**Consultation Response from KC,
Ecology Unit**

2024/90476 Moss Edge Farm, Moss Edge Road, Holmbridge, Holmfirth, HD9 2SD

Demolition of Pole Barn and erection of one dwelling

Date Responded: 12/04/2024

Proposed North East Facing Elevation
Scale 1:100

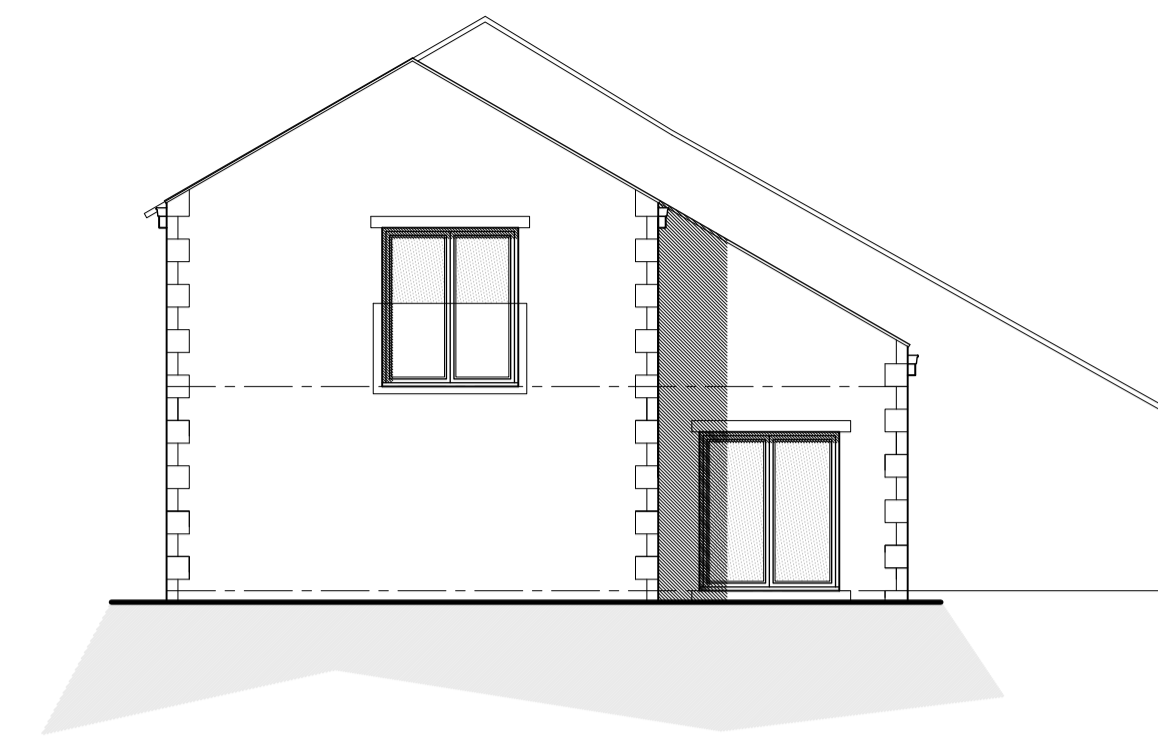
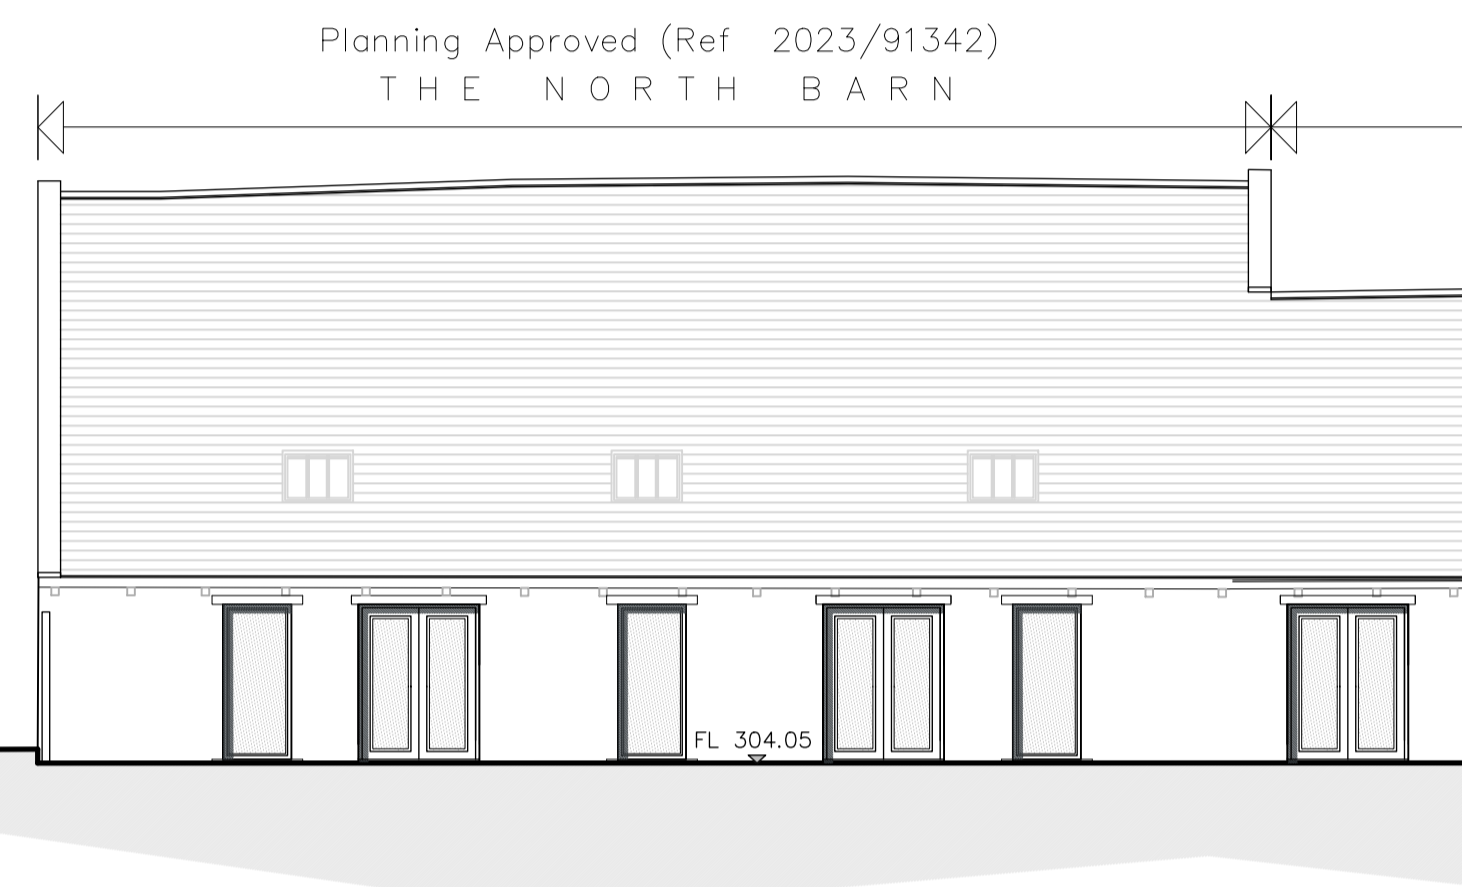
1. Prior to the commencement of the development, a plan detailing the positioning and location of one sparrow terrace shall be submitted to and approved in writing to the local authority.
